Recommendation Report for Planning Permission for Works or Extension to a Dwelling

REF NO: BE/142/21/HH

LOCATION: 44 Elbridge Avenue
Bersted
PO21 5AD

PROPOSAL: Erection of single storey side extension

Title
PROPOSED ELEVATIONS

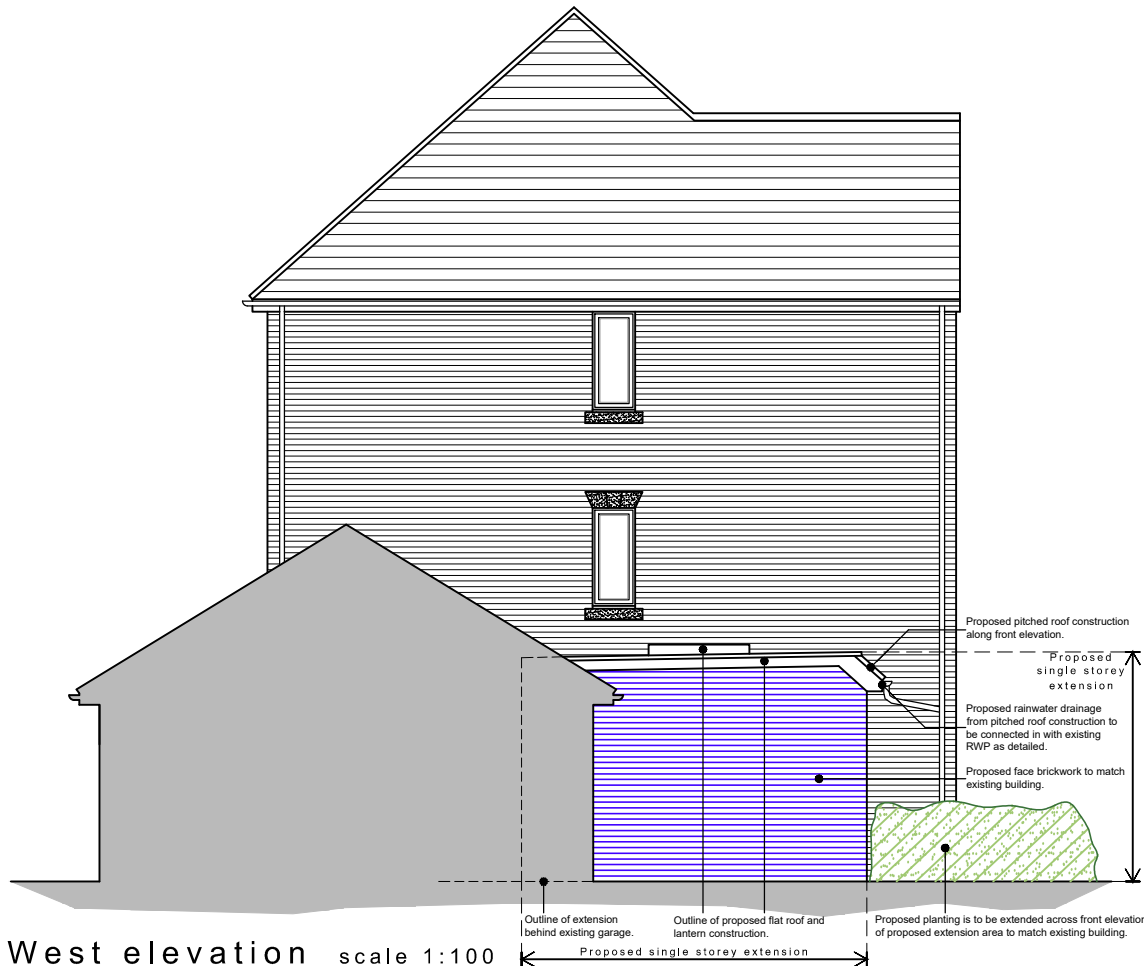
The extension will be single storey and is set around 1.2m behind the principal elevation. The surrounding properties are similar in design and appearance and the alteration would be slightly out of character, with no similar side extensions in the area. However, this is not considered significant with the height modest and with materials to match existing with feature stone head and cill detail surrounding the windows, this will help to ensure that the extension will appear well integrated with the host dwelling and area.

Section M of the Design Guide states side extensions should be 'Set back from the front of the house in order to play a subservient role to the original building: 1-1.5m for the ground floor.' The proposal complies with this. It should also 'Responds to existing building design in terms of roof pitch, and uses complementary and integrated materials and elevational design'. Materials match the existing which ensures its integration with the area.

It will have a width of 6.3m and a depth of 4.35m. This does not extend beyond the rear of the dwelling. It will have a height of 3m, which will be flat roof with a small pitch to the front elevation.

There will be 2 windows to the south which front the street scene and doors to the rear with views over the rear garden.

Title
PROPOSED FLOOR PLANS

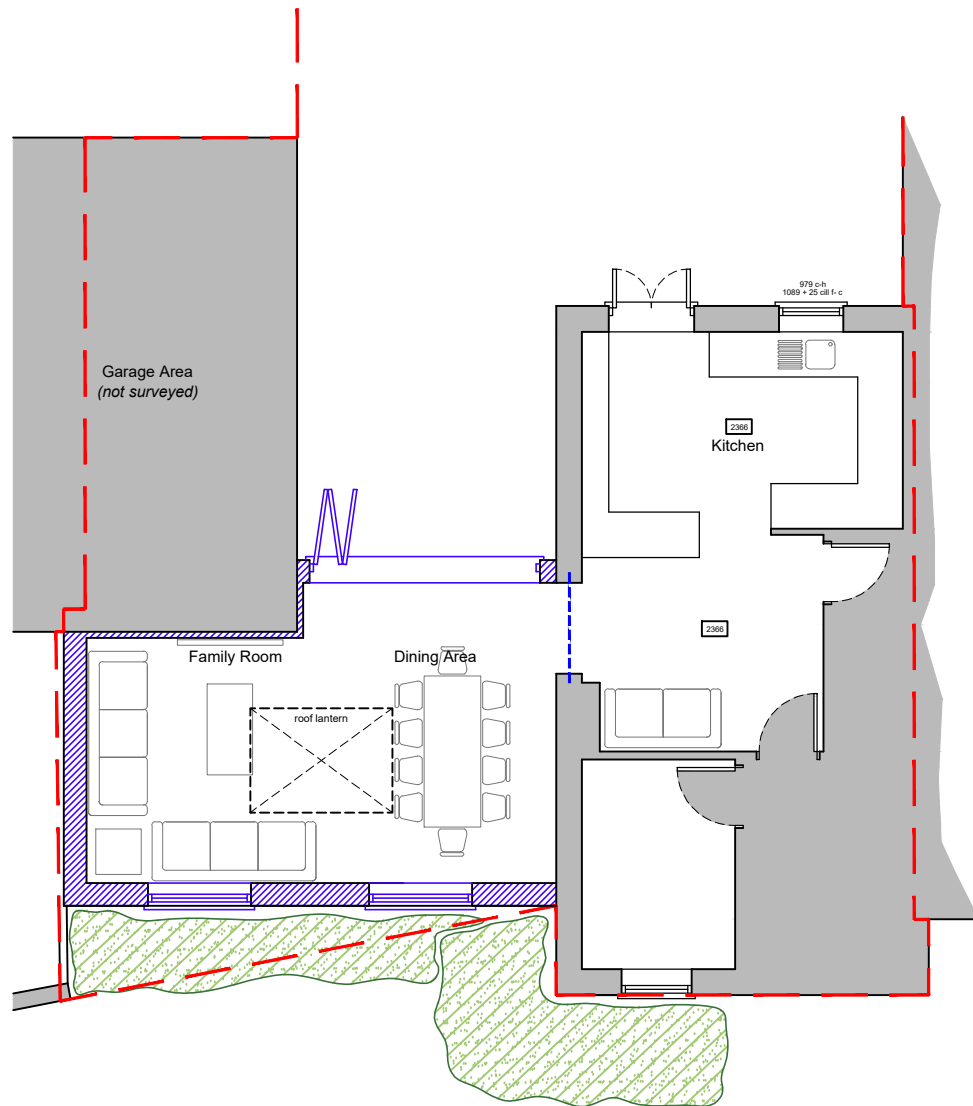
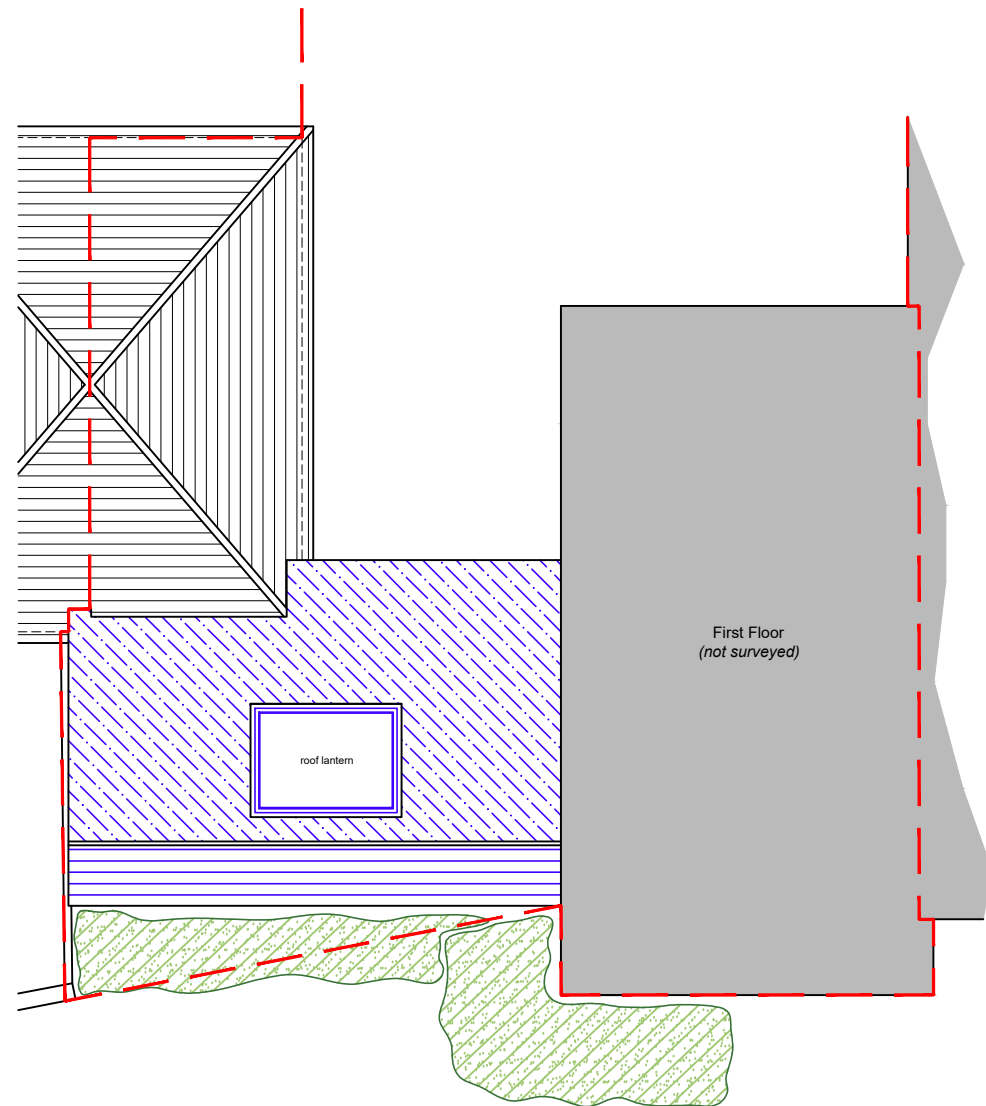
The host dwelling is a three storey town house with a detached garage to the west, with access to this from the rear of the site. The extension will be sited to the west and extend from the side of the host dwelling and along the rear of the garage, with a width of around 6.3m. There is a brick wall that runs along the boundary to the front and this will be removed in part to allow for the extension.
